Modification to approved Torrens Title Plan of Subdivision

***Royal Rehabilitation Centre Sydney, 600-640 Victoria Road,
Ryde***

MP07_0100 MOD 2

Director-General's
Environmental Assessment Report
Section 75W of the
Environmental Planning and Assessment Act 1979

PLAN OF SUBDIVISION OF LOT 5 DP1129793

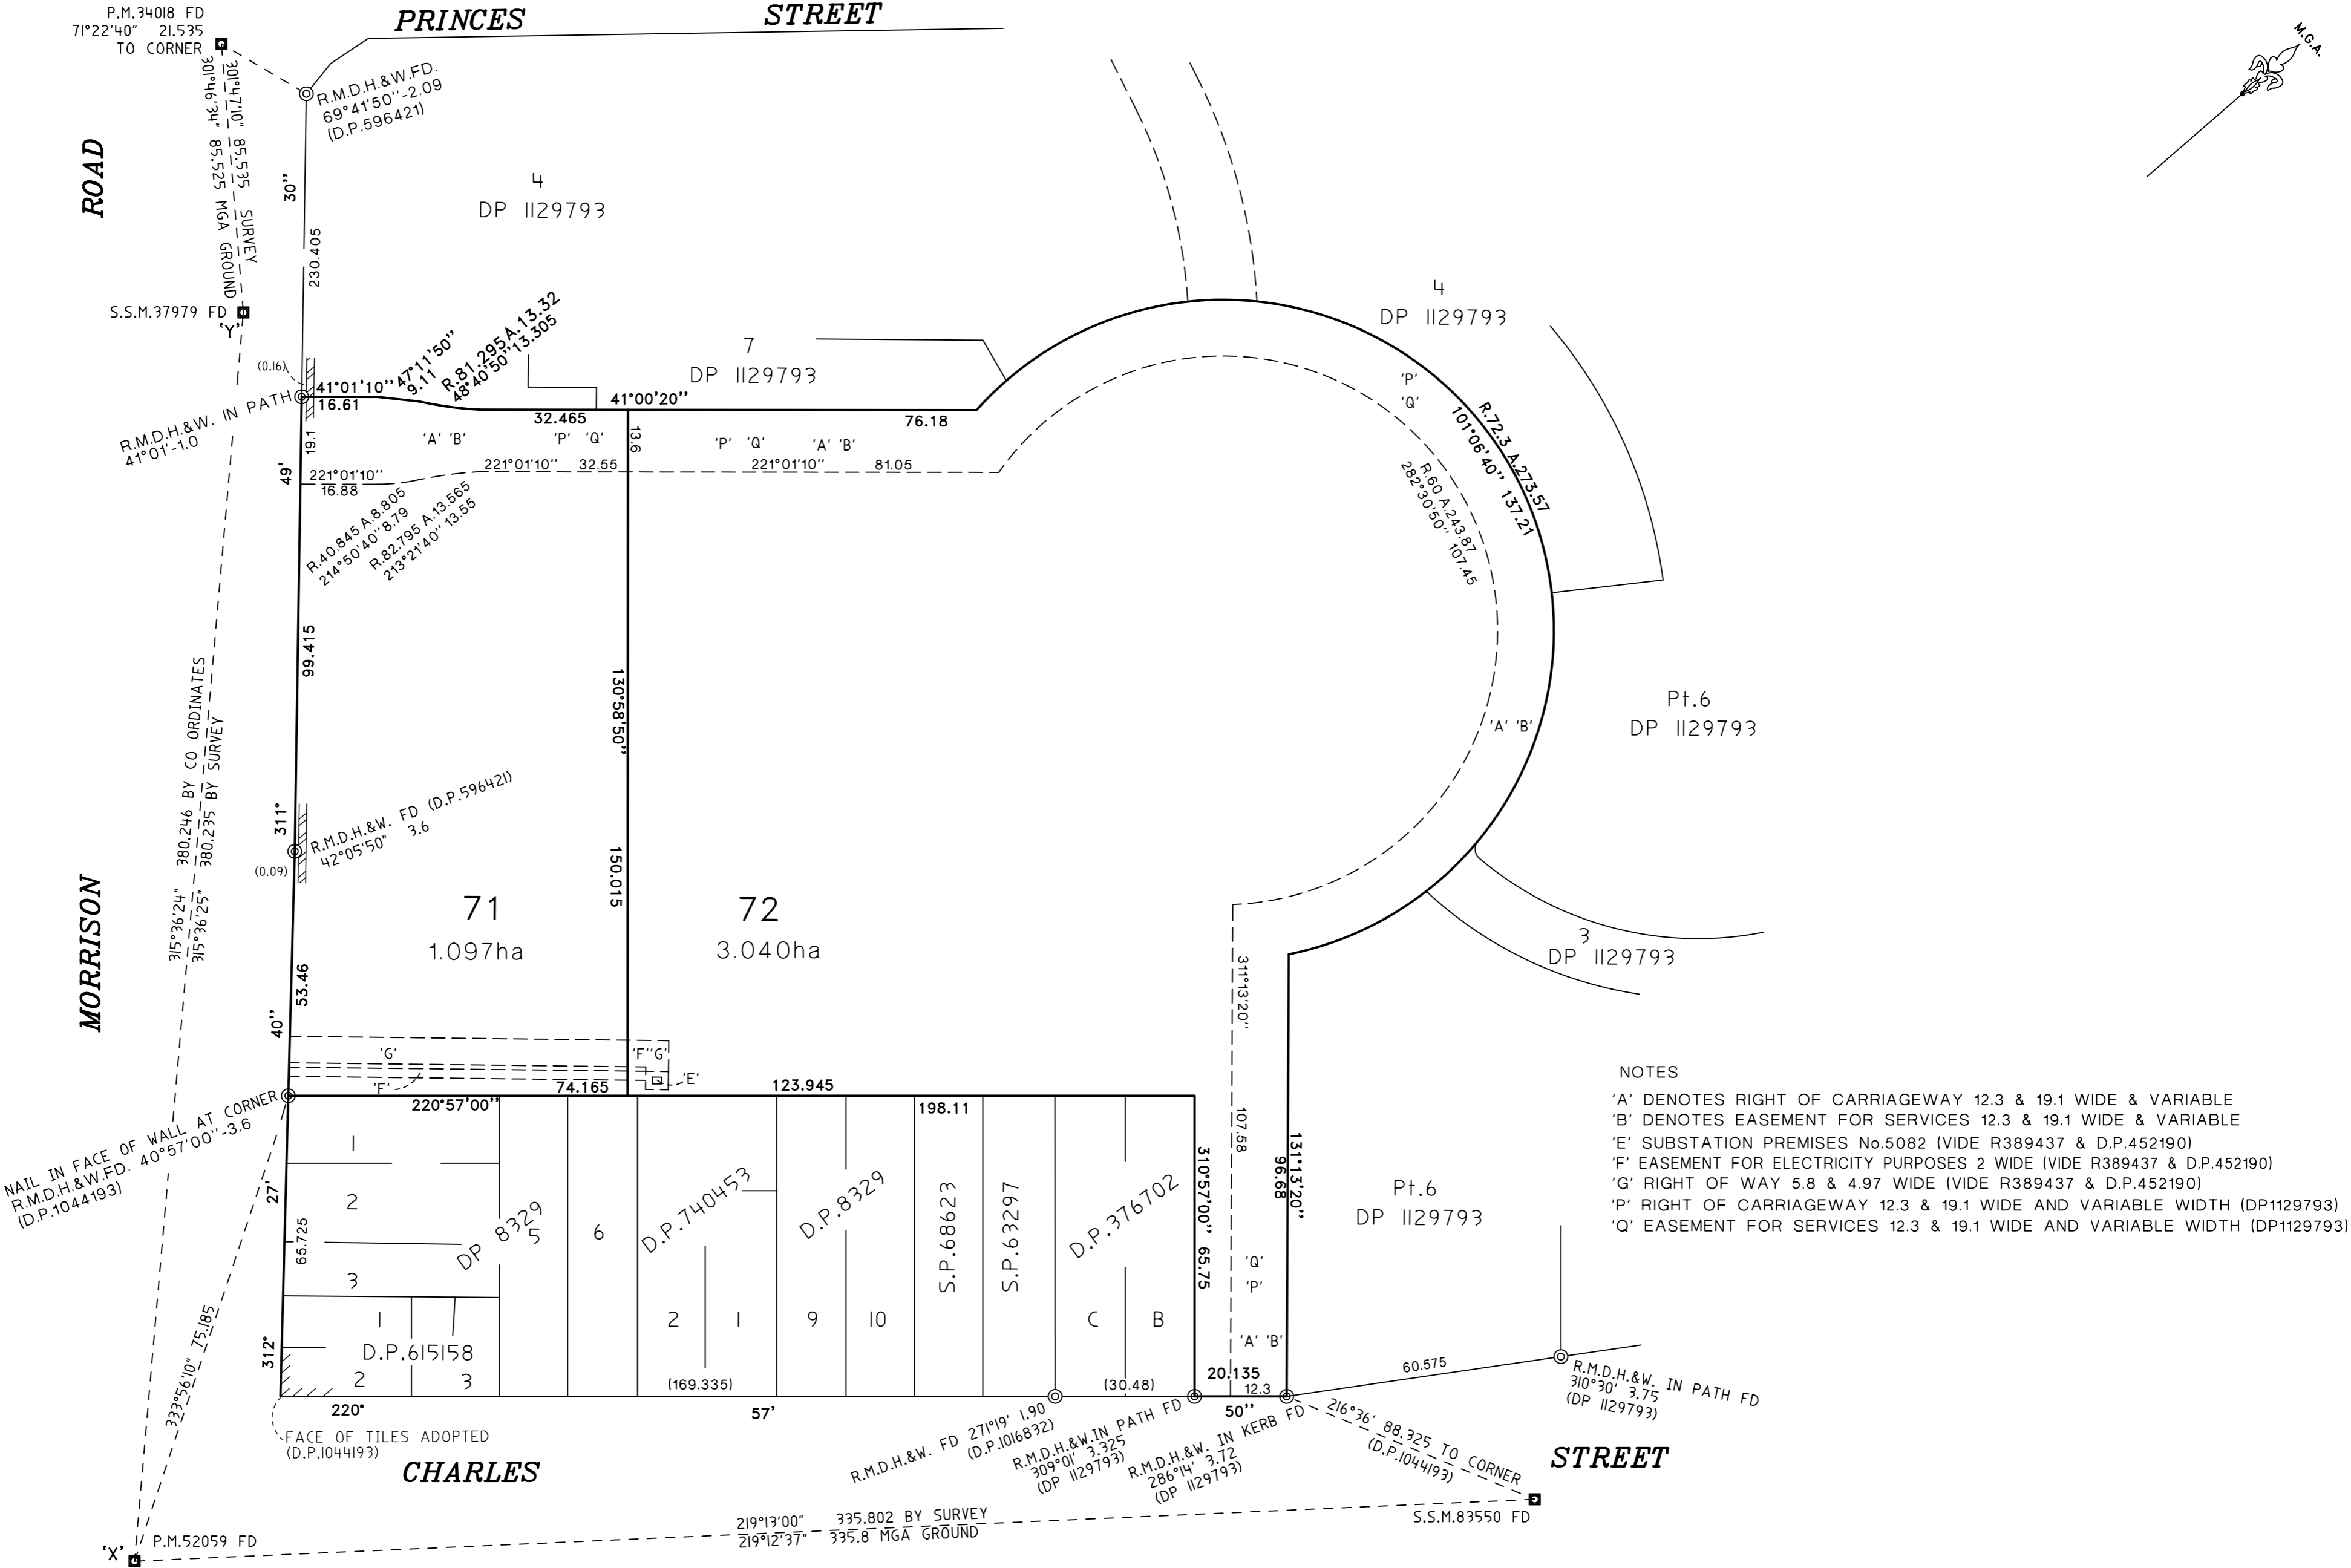
- Lot 5 is currently fed by a single power supply (D1 of S5082). This supply needs to be separated into two in order to serve both Lots 71 and 72 via an easement;
- any additional load on the site will require a new electricity kiosk which will be a contestable project funded by the developer; and
- depending on the load, Lots 71 and 72 may require separate substations funded by the Proponent. The issues raised by Ausgrid are addressed in Section 5.4.

The proposed line of subdivision does however conflict with the two level basement car park and at-grade car park approved as part of the Health Facility development and the at-grade car park located between the Retail Precinct Building and the Weemala Bed Facility.

The basement car park provides parking for both the commercial and health care components and its footprint stretches across the proposed line of subdivision. The car park only has one vehicle entry located in the southeast of the building via proposed Lot 72. This would present access and egress issues for visitors to both components of the approved building should the sale of the commercial component take place in the future.

Likewise, access to and use of the at-grade car park located adjacent to the commercial component of the Health Facility Building (Lot 71) would not be permitted if the commercial component is sold. Therefore, a covenant is recommended to be placed on the title of Lot 71 to ensure users and visitors associated with the Main Health Facility (Lot 72) have access to and ongoing use of the at-grade car park.

The proposed line of subdivision divides the at-grade car park located between the Retail Precinct Building (Lot 71) and the Weemala Health Facility Building (Lot 72). Vehicle access to the car park is located with proposed Lot 71. Access and use of this car park would therefore not be permitted for users or visitors to the Weemala Facility if the retail building is sold. In this regard, a covenant is recommended to be placed on the title of Lot 71 to permit users and visitors of the Weemala Bed Facility ongoing access and use of the car park.

F1 Covenant for use of the Basement Car Park and at-grade Car Parks

- *a covenant shall be placed on the title of Lot 72 requiring the ongoing unrestricted access to and use of the shared basement car park below the Health Facility to users of Lot 71;*
- *a covenant shall be placed on the title of Lot 71 requiring the ongoing and unrestricted access to and use of the at-grade car park (located in the western corner of Lot 71) to users and visitors of Lot 72; and*
- *a covenant shall be placed on the title of Lot 71 requiring the ongoing and unrestricted access to and use of the at grade car park (located adjacent to the Pharmacy Building) to users and visitors of the Lot 72.*
